Internet Ref: ECH947
Our Ref: WA/72/12/
Case Officer:
Mrs S Leeson

Revisions to previous approval WA/66/11 for the proposed refurbishment works to the
Holly Tree pub including 4 no. bed & breakfast rooms

The Holly Tree Public House The Street Walberton

cons_resp

GROUND FLOOR PLAN AS PROPOSED

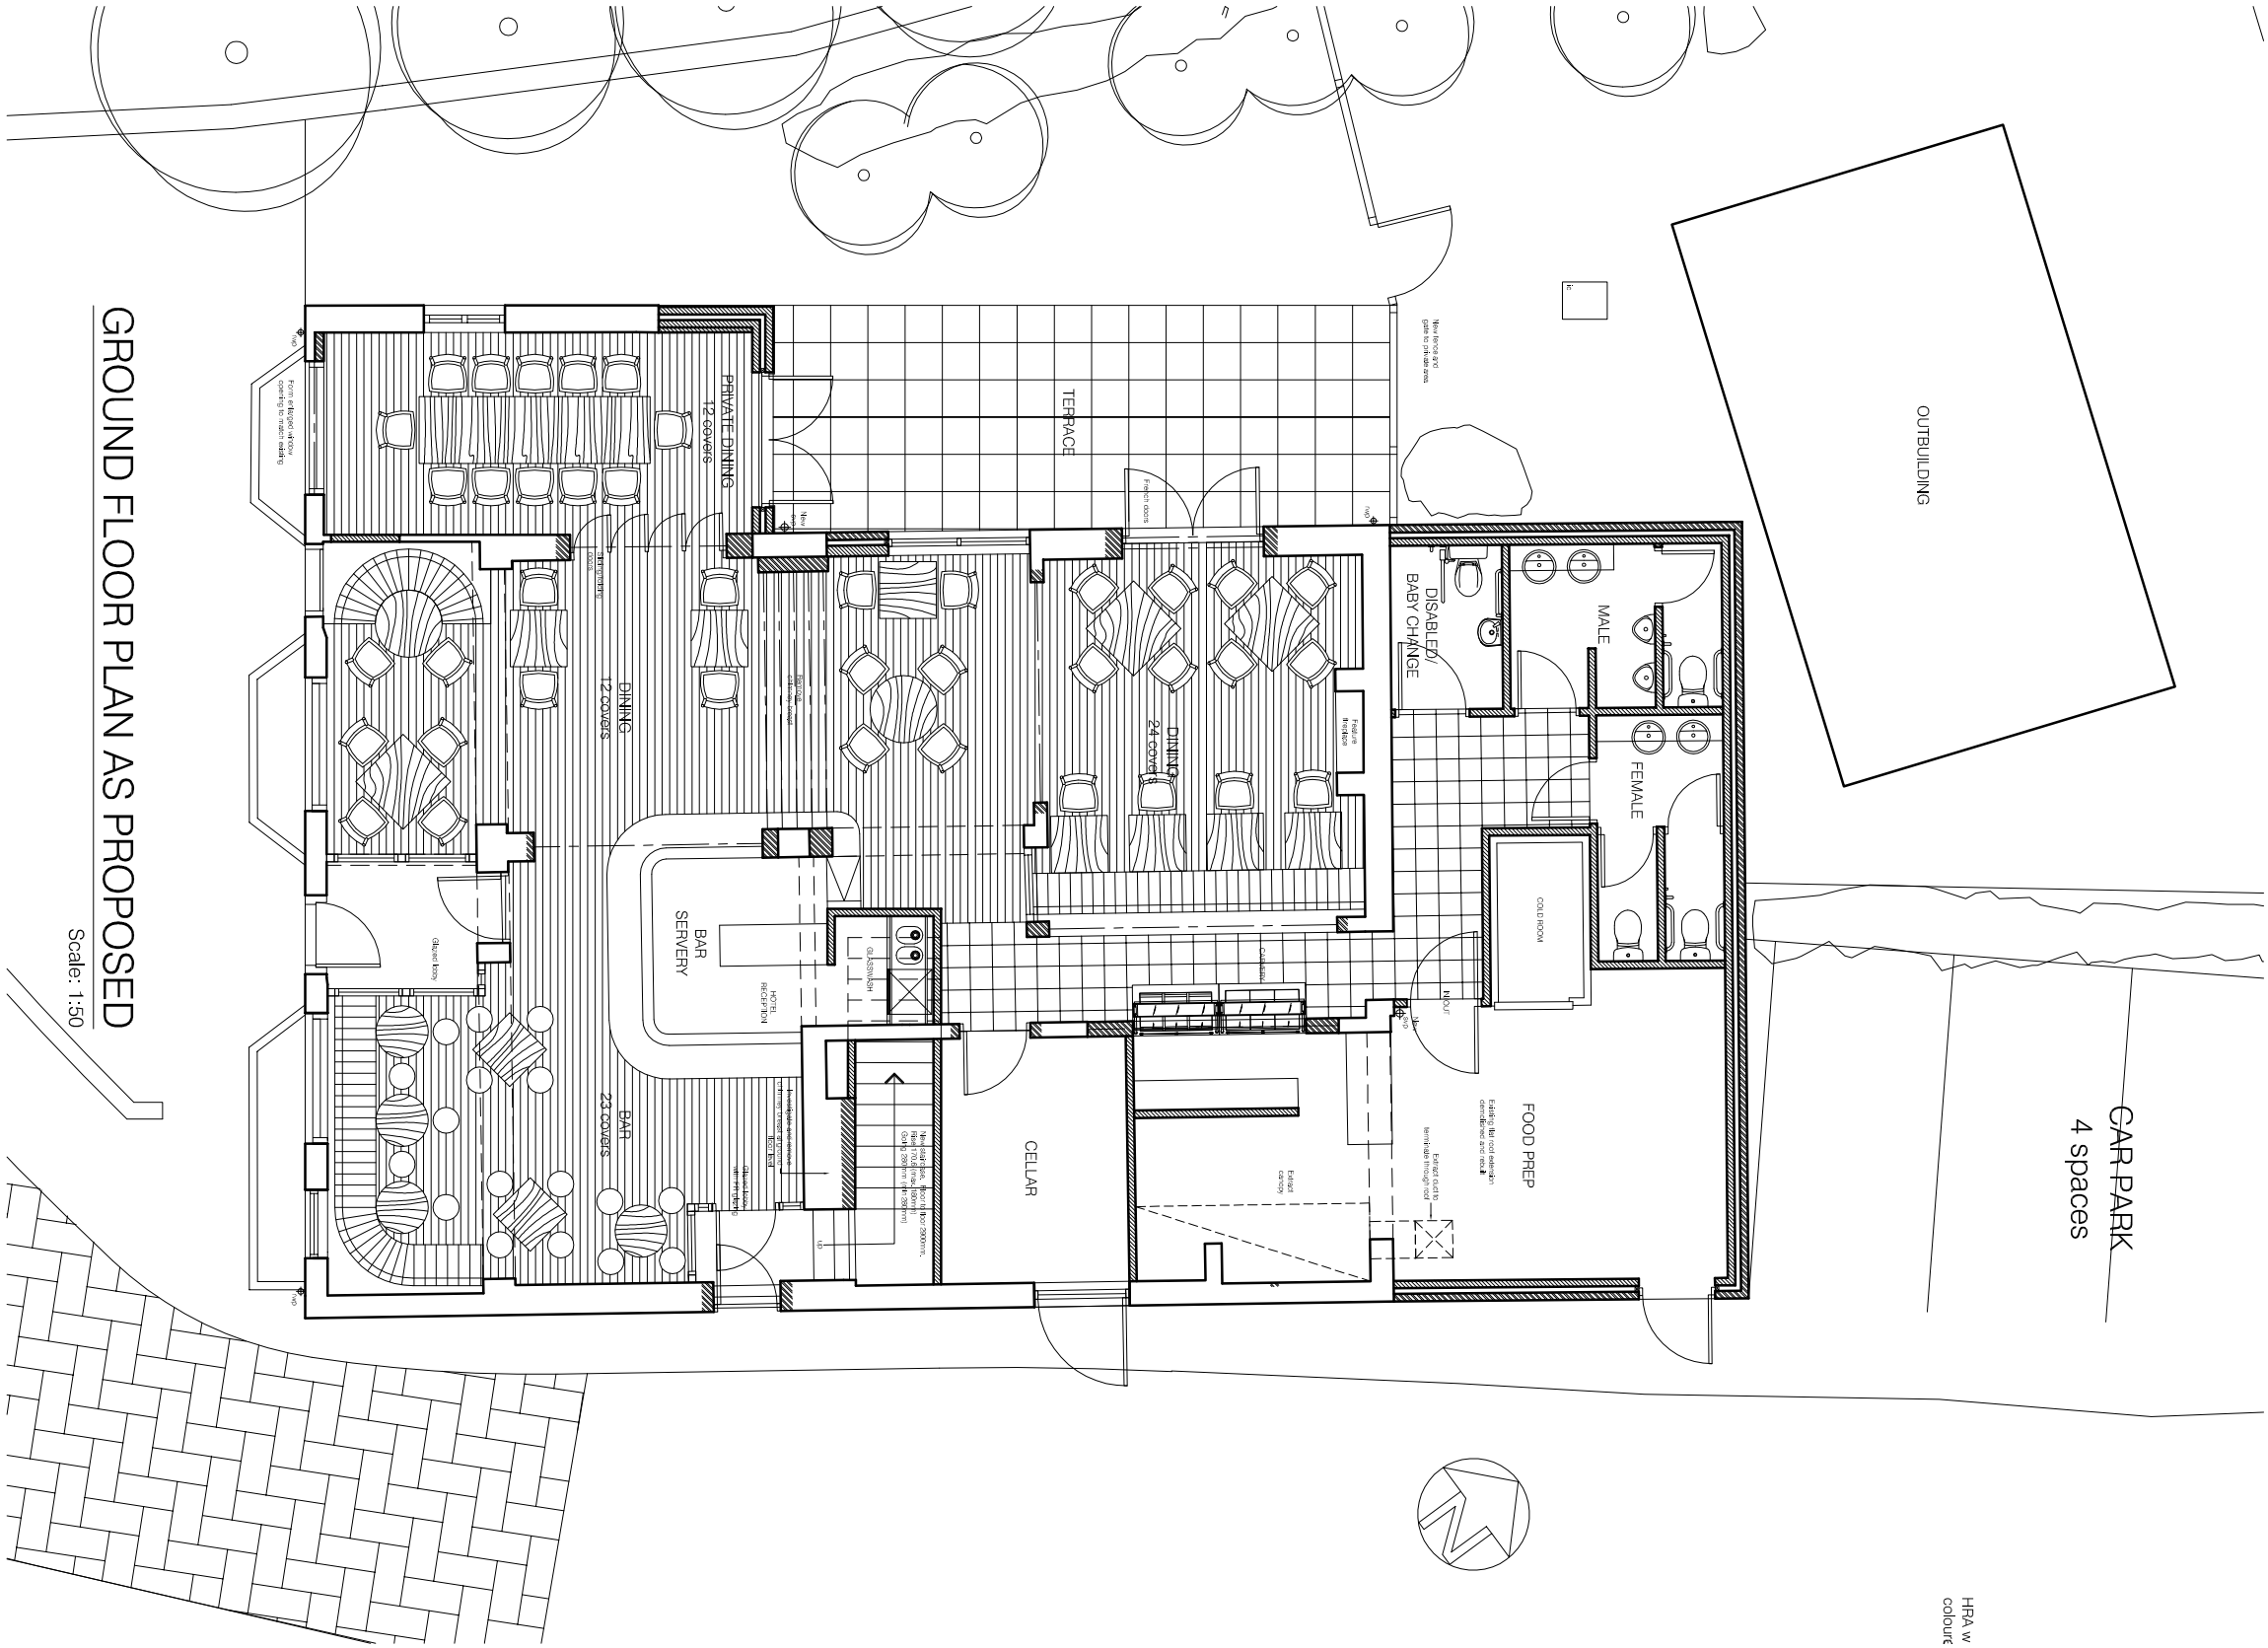
Inadequate information on kitchen layout, storage and ventilation extract system.
